Reference No: 2020/62/91897/W

Site Address: 69, Town Gate, Hepworth, Holmfirth, HD9 1TE

Description: Demolition of existing extension and erection of two storey side extension, porch extension and replacement windows (within a Conservation Area)

DECISION – Full Conditional Permission

Date:	Scale @ A1:	Drawn by:
JUN 20	1:50/100	AB
Project No:	Drawing No:	Revision:
142	(0-) 02	B

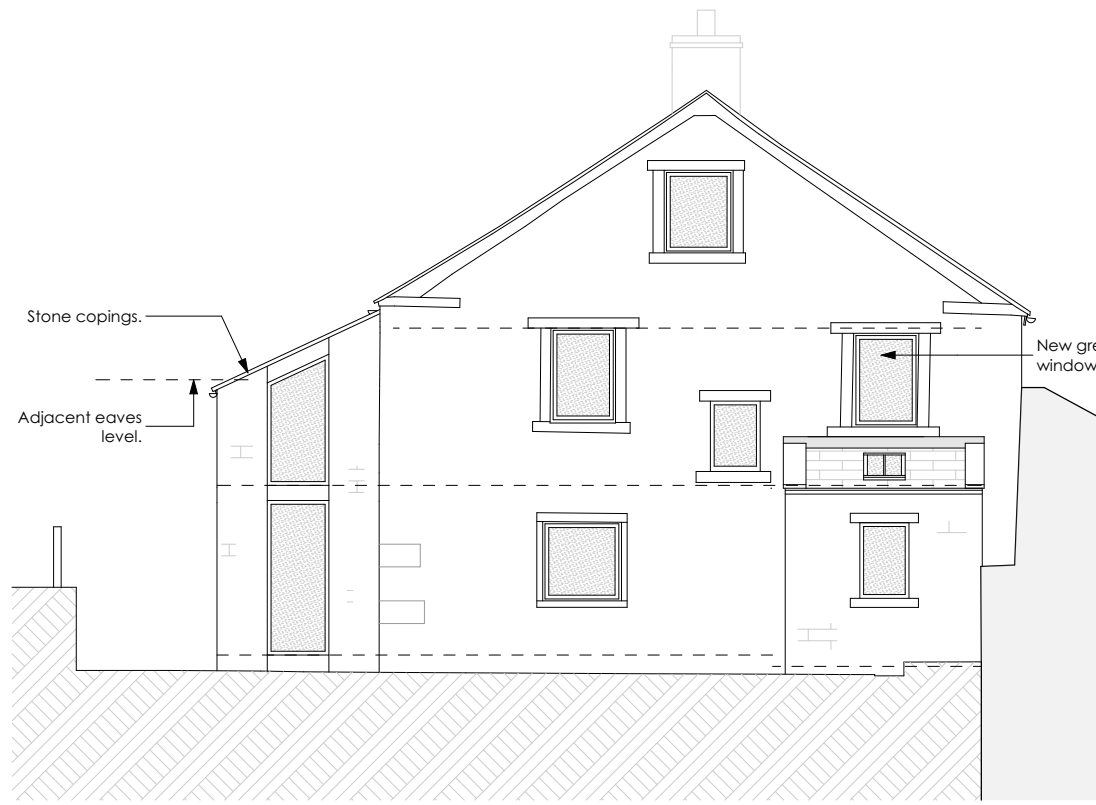
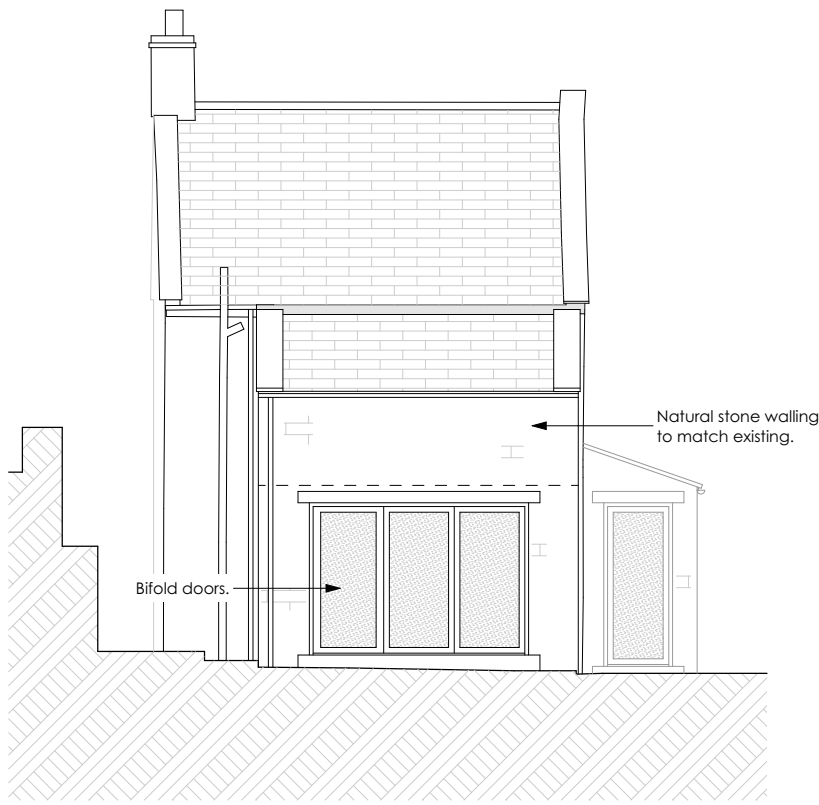
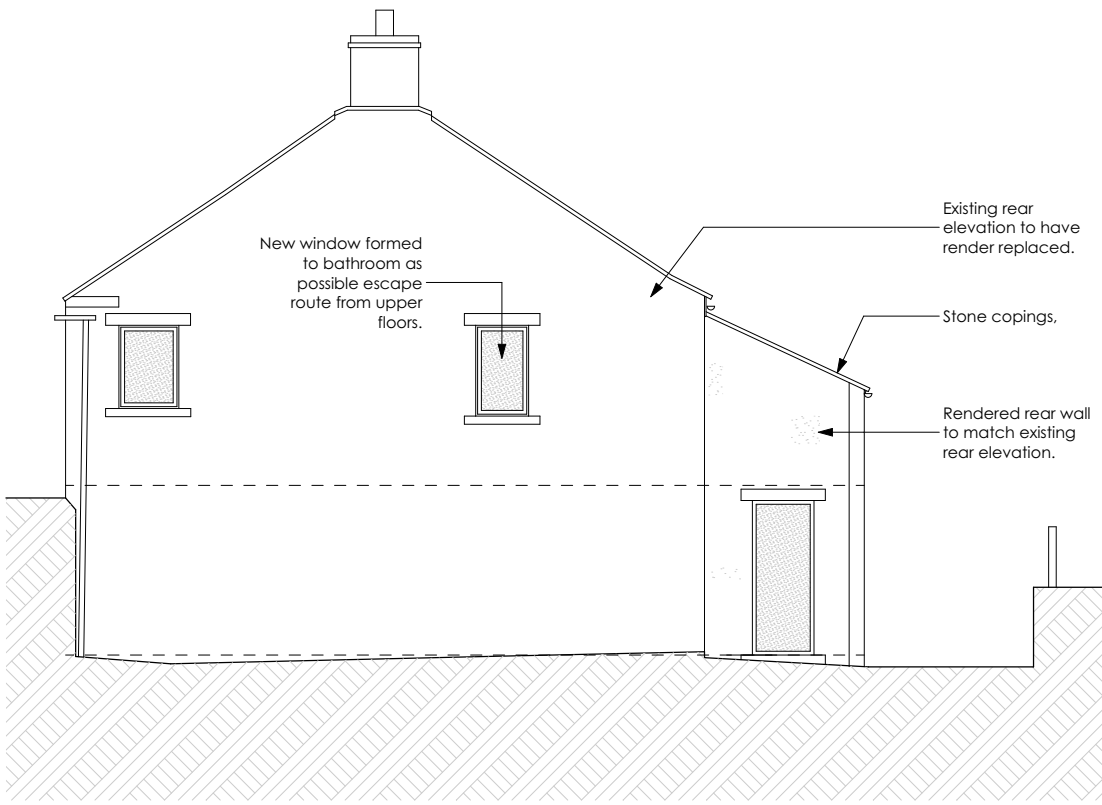
Concern was raised with the agent regarding the prominence of the proposed front porch and the design of the openings within the two-storey side extension. As such, final amended plans have been sought to reduce the overall size and scale of the front porch. These were received on the 19th August 2020.

In terms of fenestration, amendments have been sought to re-configure the design and size of the window proposed within the front elevation, in order to ensure that it would have a similar visual appearance to the openings in which exist on the front elevation of the host property. A door will also be inserted into the southern facing side elevation to allow access.

Nonetheless, initial concern was raised with the agent regarding the design of the fenestration within the front elevation of the side extension, given that this element would be readily visible from public vantage points. However, justification has been provided by the agent regarding this matter, as the tall windows are required in order to keep the internal height as low as possible.

Furthermore, justification was also provided by the agent regarding the elongated windows within the front elevation of the side extension, in which KC Conservation and Design considered to be acceptable.

In order to overcome the concerns raised by Conservation Officers, amended plans were sought. In this instance, the works proposed were to reduce the overall footprint of the front porch and therefore officers did not consider it necessary to re-advertise the application.

Having taken this into account, KC Conservation and Design have raised no objection, as the proposed fenestration will allow the extension to appear as a contemporary addition to the original dwellinghouse. The proposed bi-folding doors within the side elevation, will also allow flexible space for the occupants of the dwelling and therefore no concerns have been raised.
